COMMUNITY & NEIGHBOURHOOD OBJECTION SUBMISSION

Application Ref: SSD-81426710 (Amended Mixed-Use Development, 138 Maroubra Road)

Submitted By: Combined Adjoining Neighbors & Surrounding Community Members

1 2 PM - JUNE 21st
1 : 500

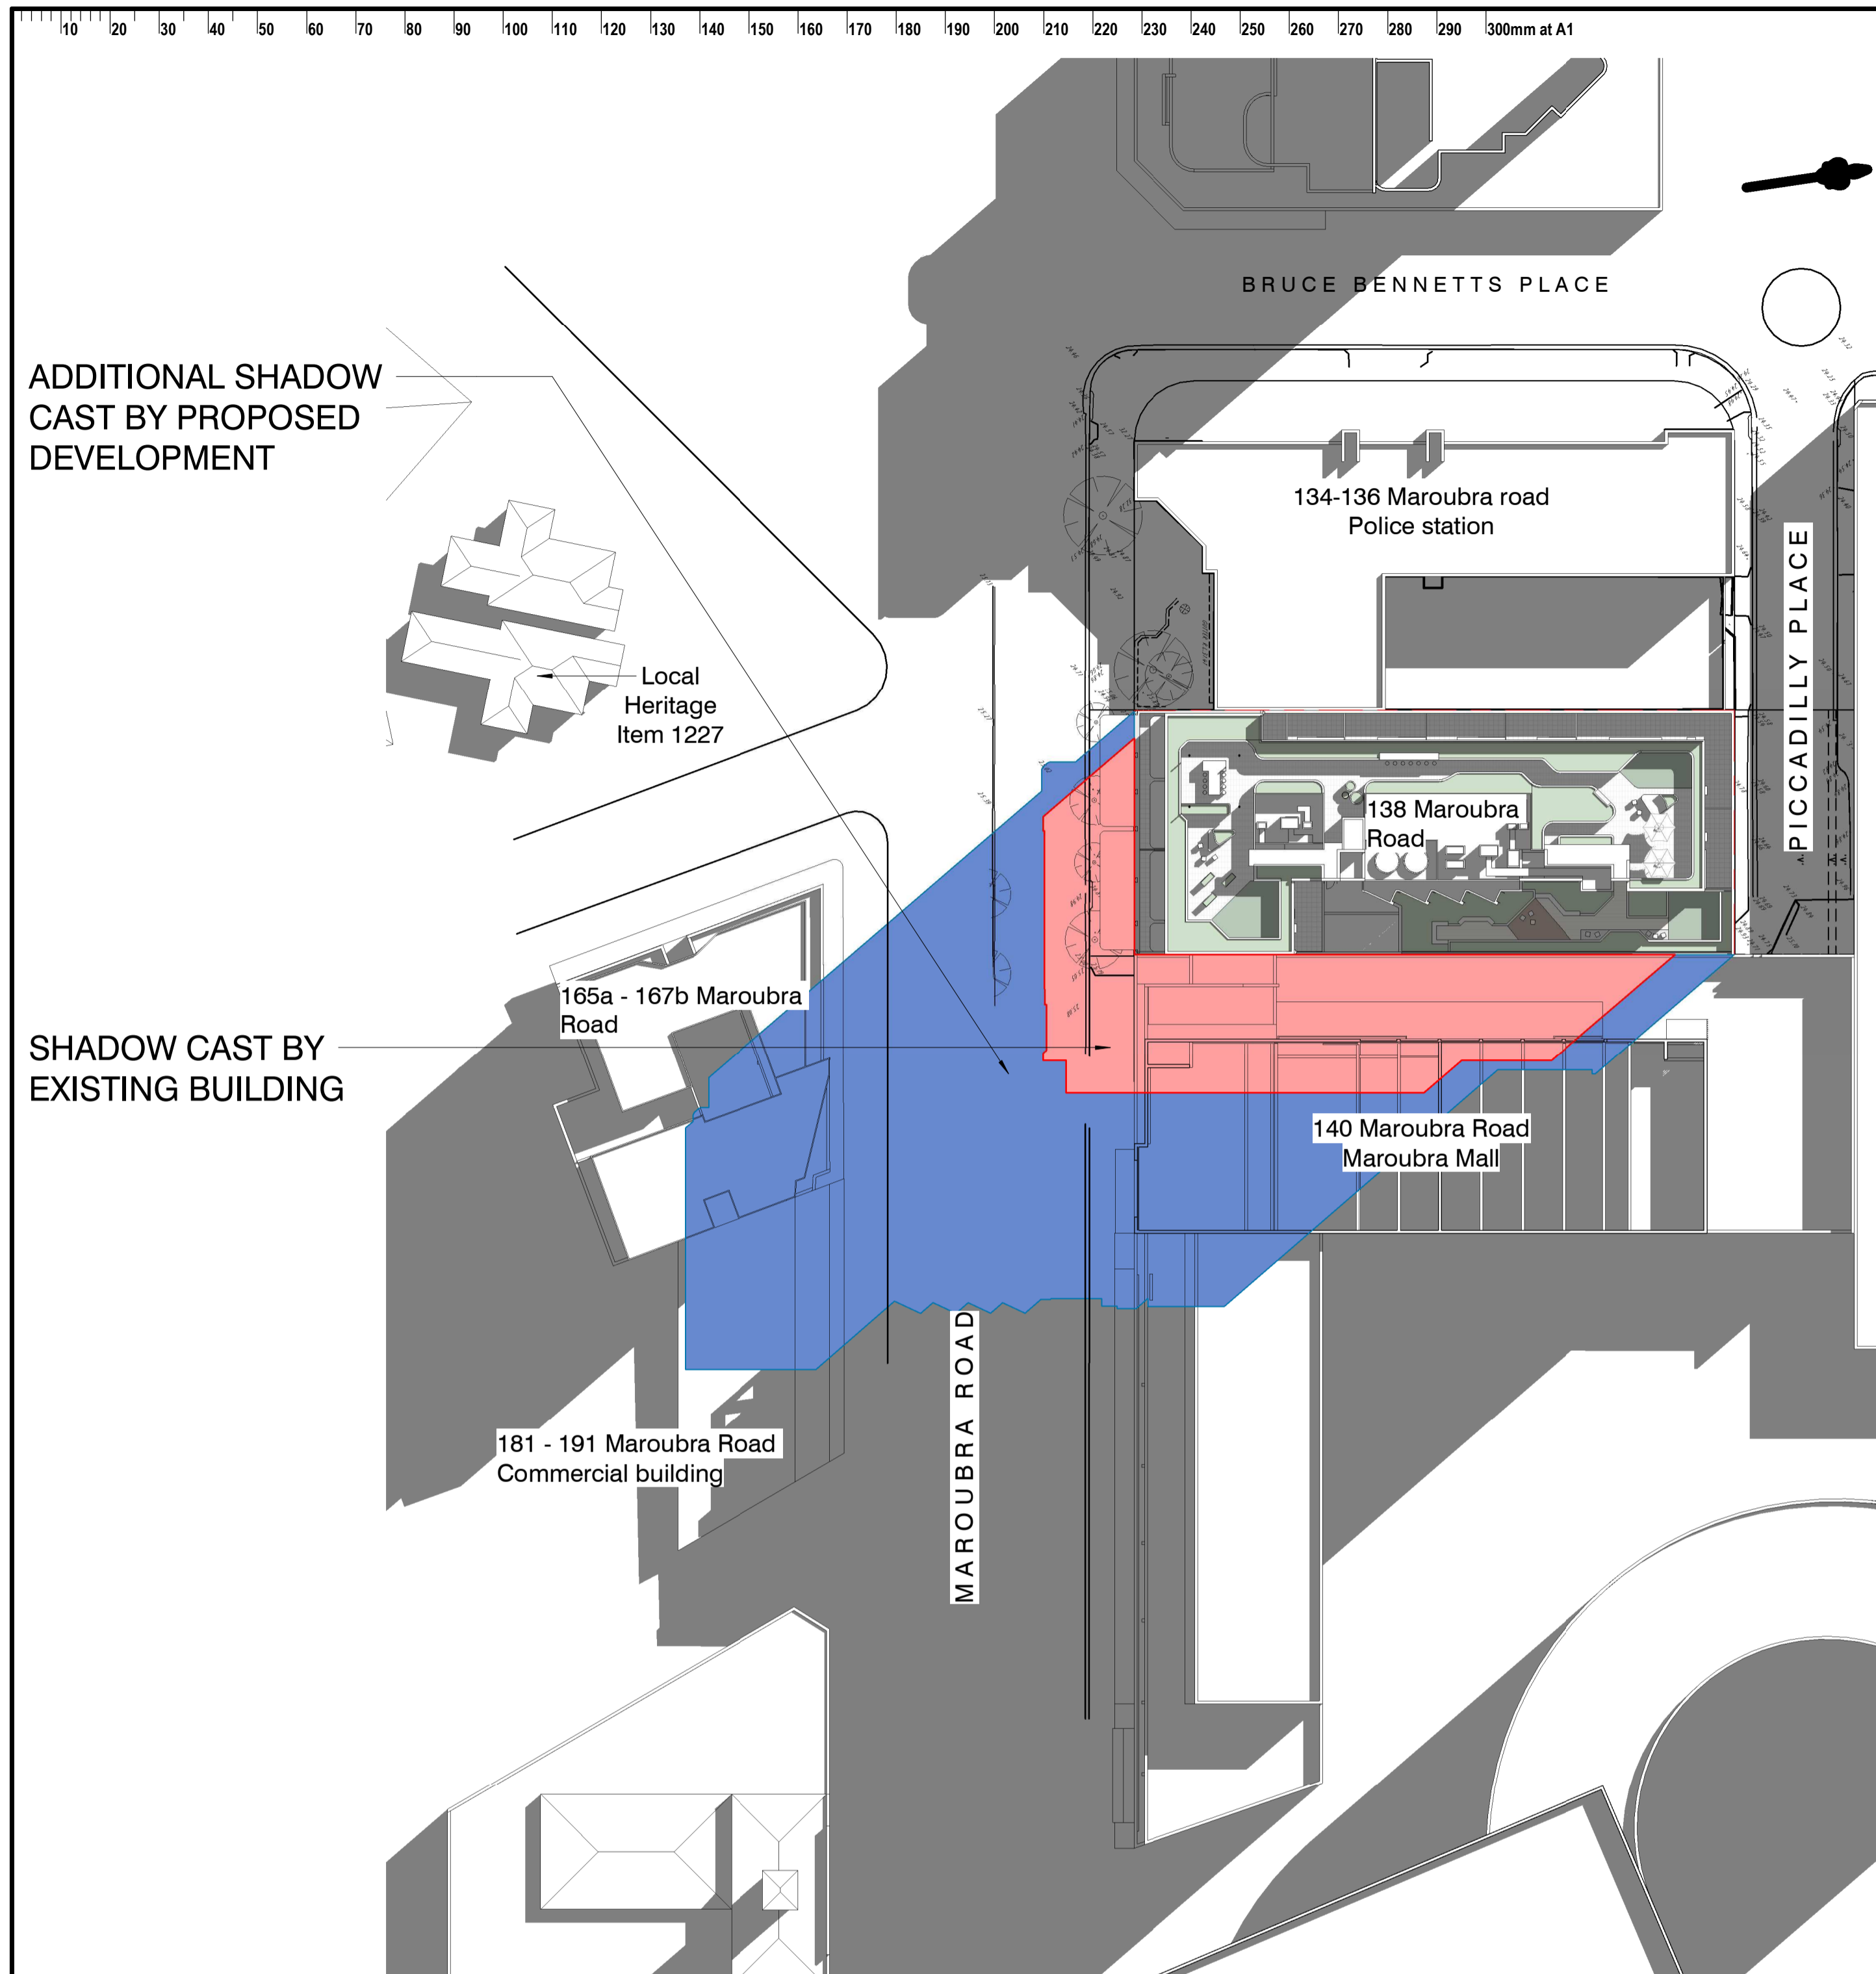
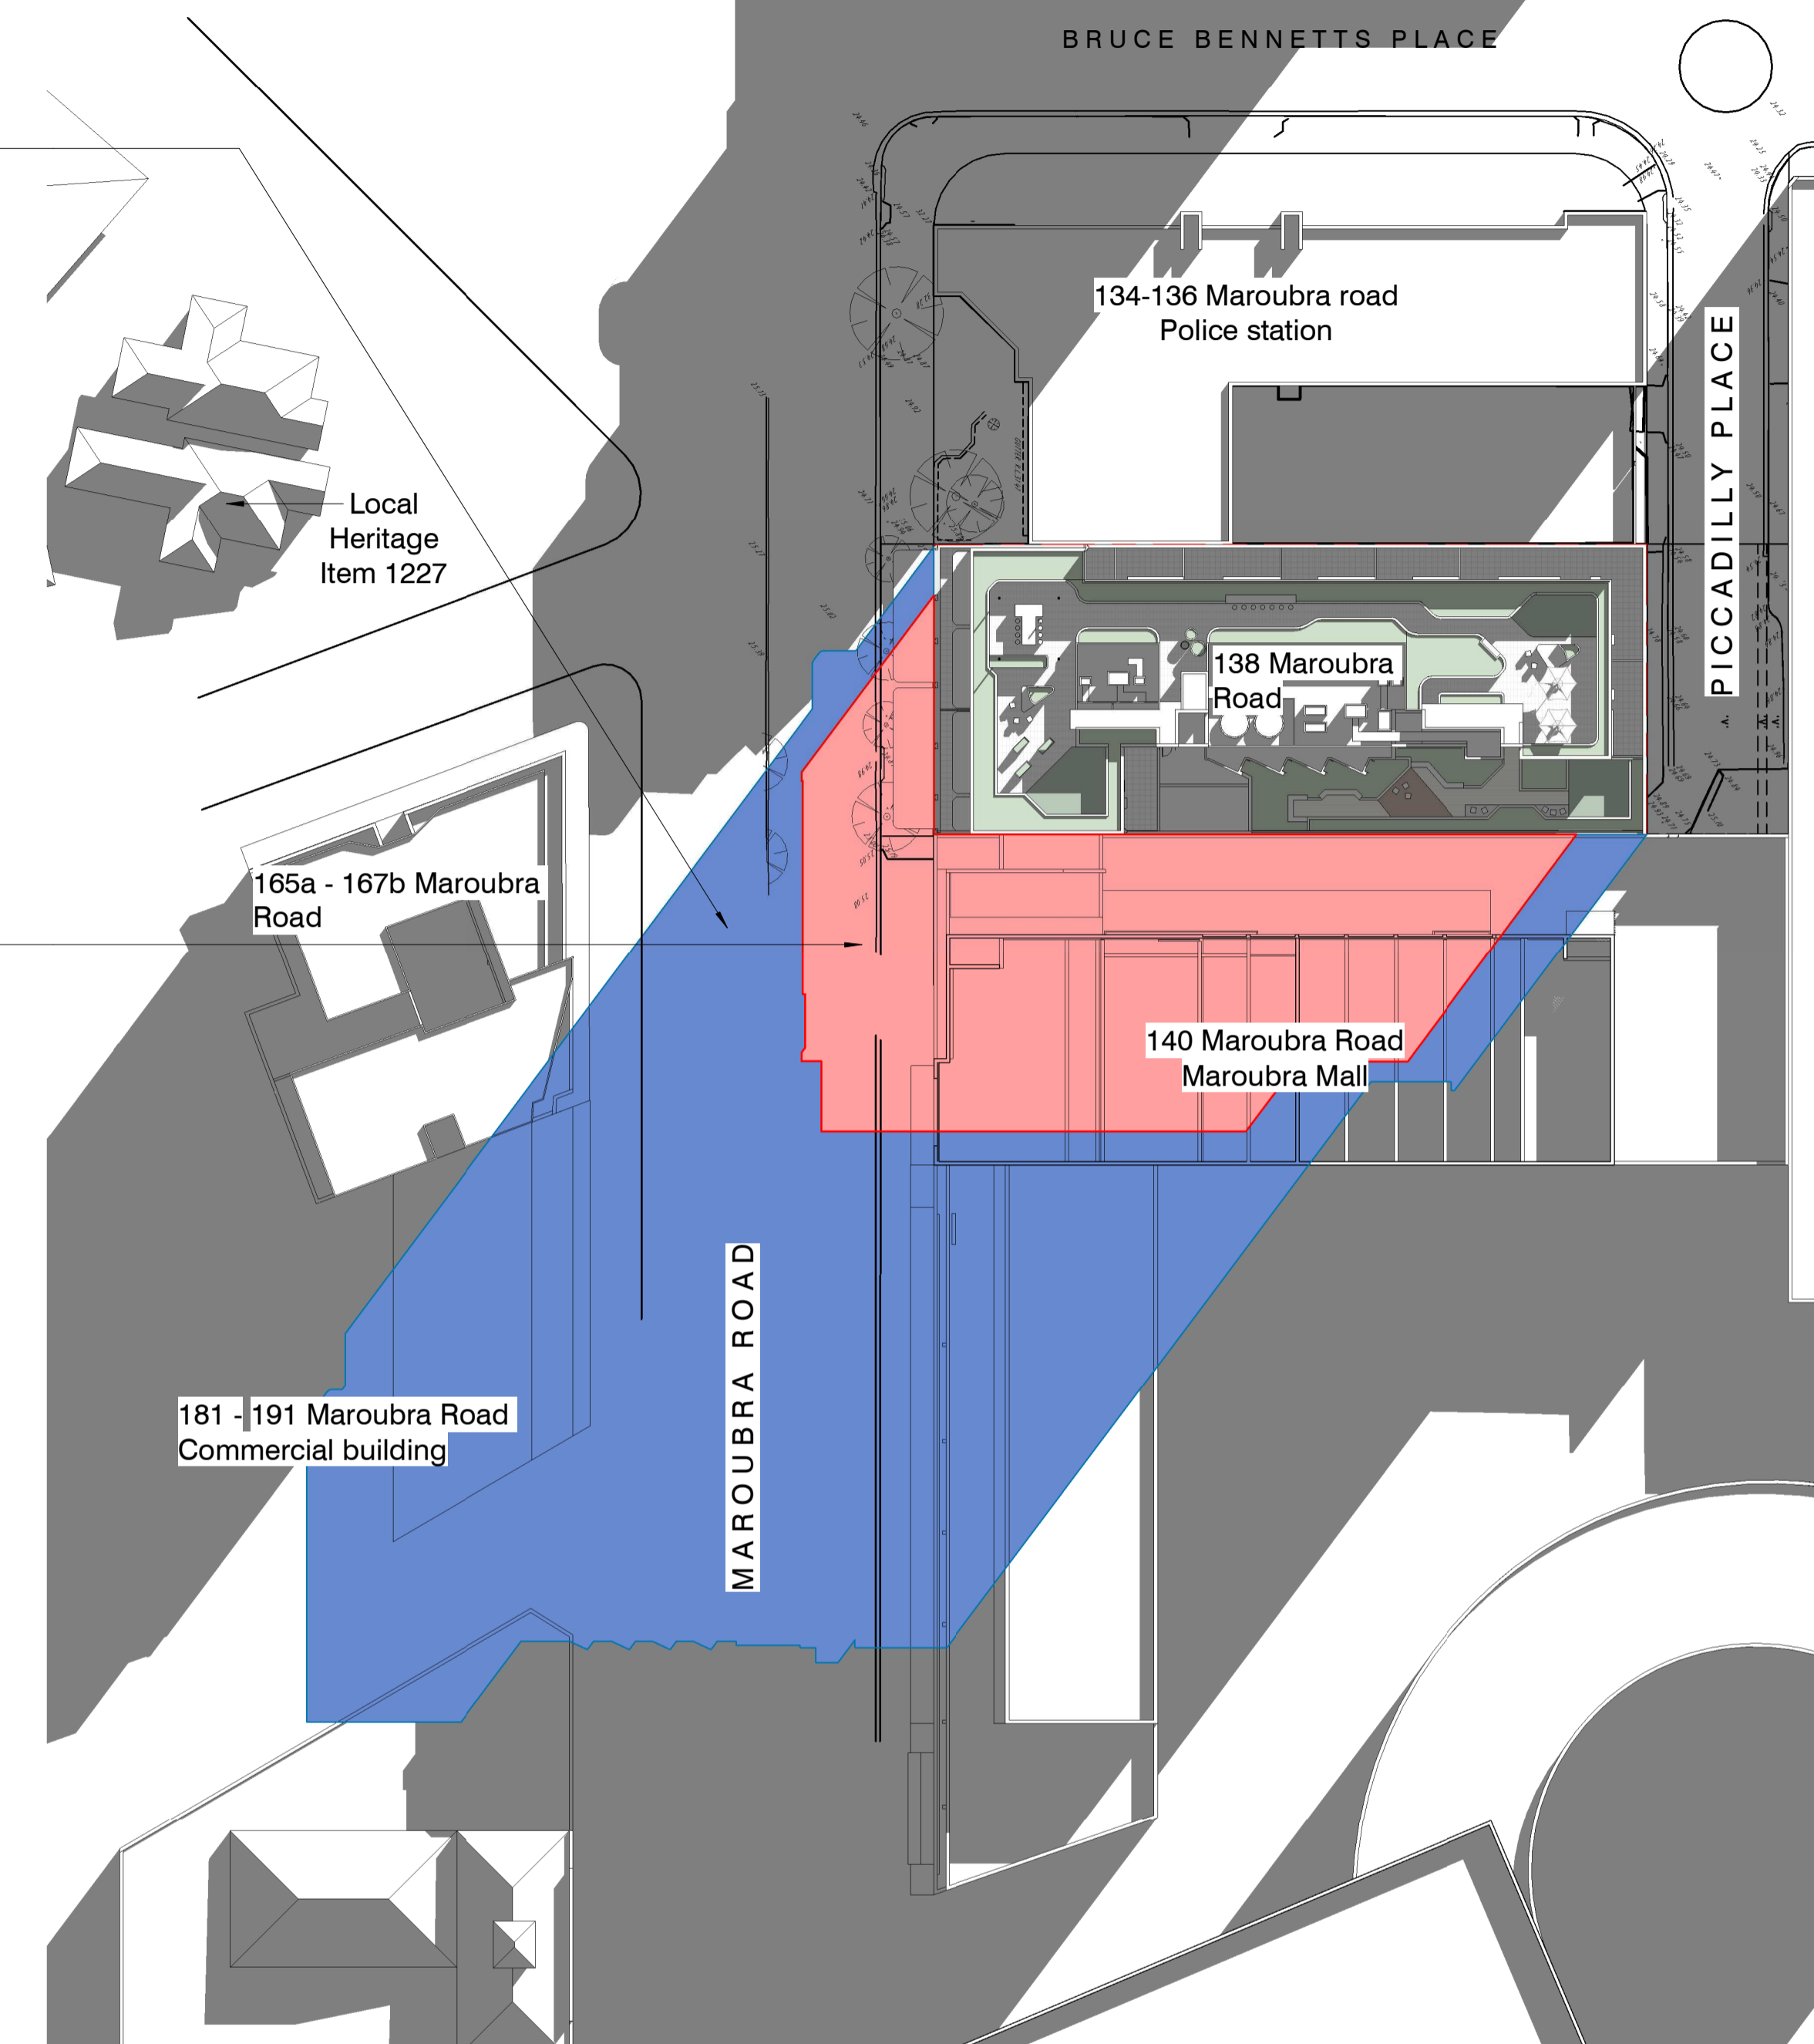
The developer's updated shadow modeling relies on broad, generic regional assumptions under the Apartment Design Guide (ADG), completely brushing aside the microclimatic impact on immediate neighbors. Erecting a deep, unarticulated 10-storey concrete structure directly to the west will plunge adjacent properties into darkness during crucial afternoon hours.

Access to natural daylight is a fundamental component of livability and passive room heating. Depriving surrounding homes of afternoon sunlight directly degrades the health and physical well-
